CITY OF ALBUQUERQUE

RE: Kingdom Muay Thai
4471 Irving Blvd. NW
Grading and Drainage Plan
Engineer's Stamp Date: 6/7/24
Hydrology File: B13D035

Based upon the information provided in your submittal received 06/07/2024, the Grading plan is **not approved** for Building Permit. The following comments need to be addressed for the approval of the above referenced project.

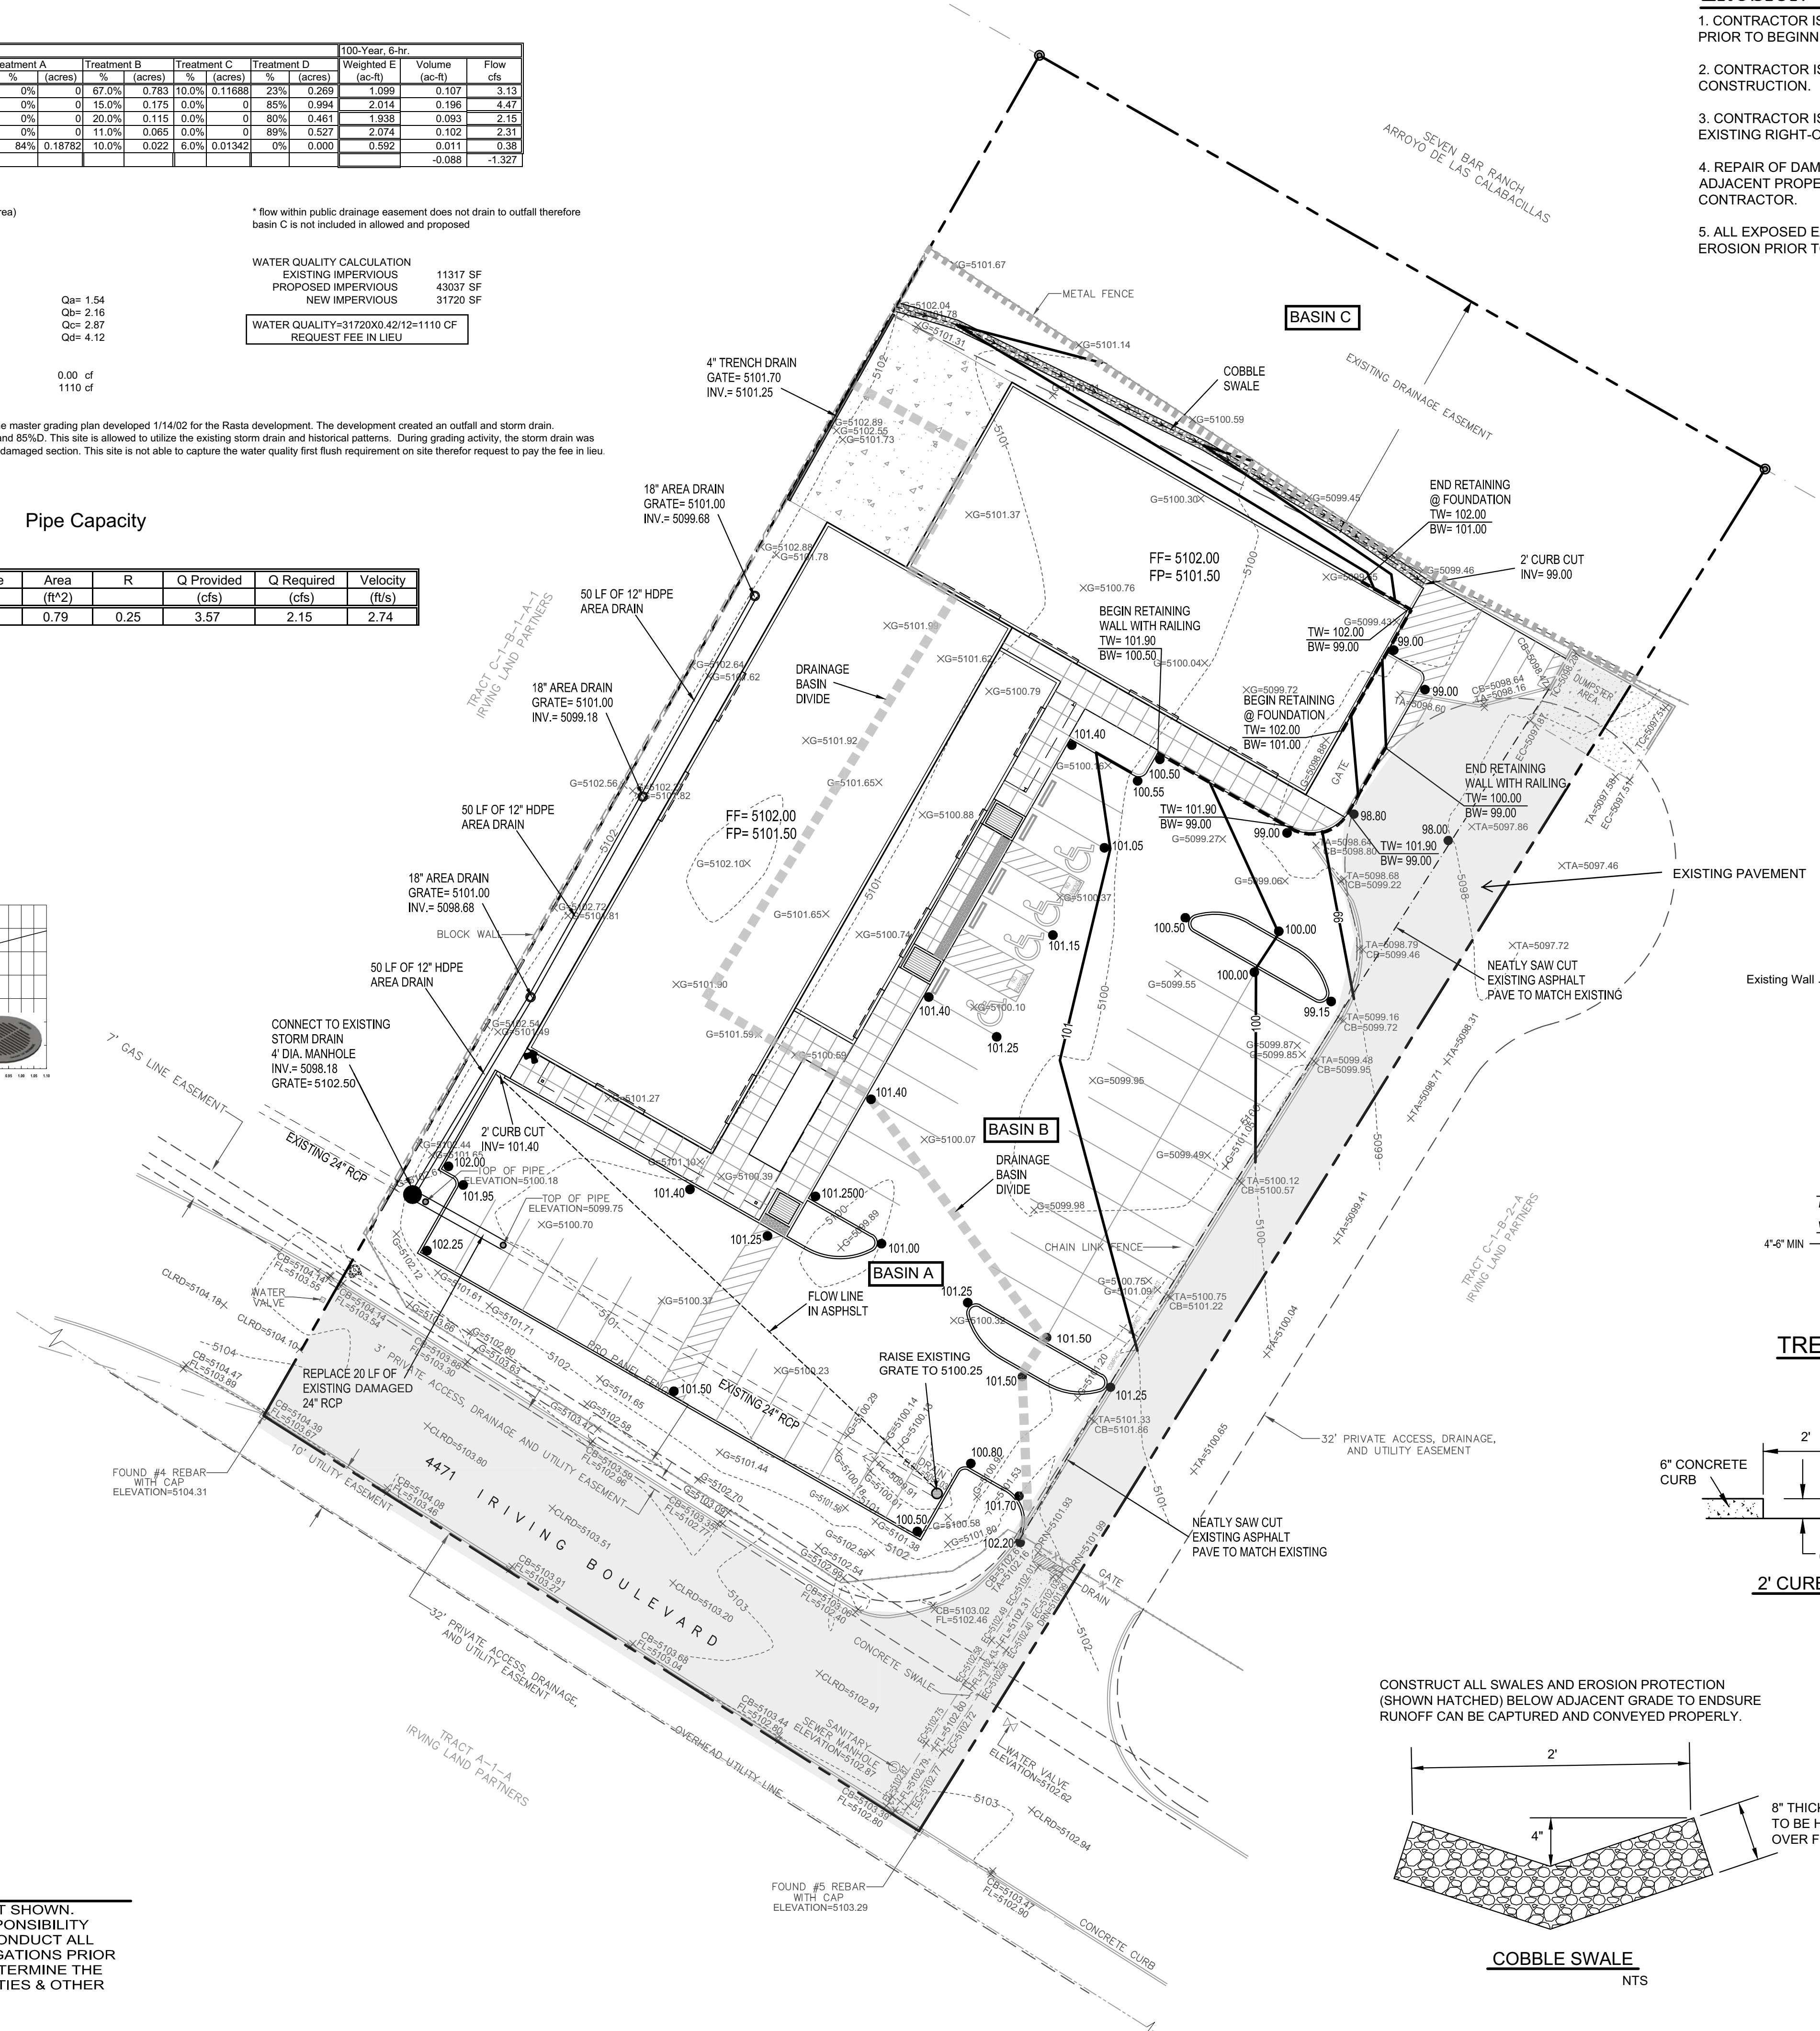
1. The calculation for the Storm Water Quality Volume (SWQV) is not correct. Per the DPM Article 6-12: *To calculate the required SWQV, multiply the impervious area draining to the BMP by 0.42 inches for new development sites...*
The calculation shown on the plan subtracts the existing area from the calculation. Please use the Proposed Impervious Area (Treatment D for Proposed A and Proposed B) to calculate the SWQV required.
2. The Narrative states that for this site, pay in lieu is requested. Per the DPM Article 6-12, Section 6-12(C)(1), the amount of payment-in-lieu will be based on \$8/cubic foot of SWQV required. The total required SWQV calculation must be included on the Grading and Drainage Plan along with calculation of the portion of the SWQV for which payment-in-lieu is requested.
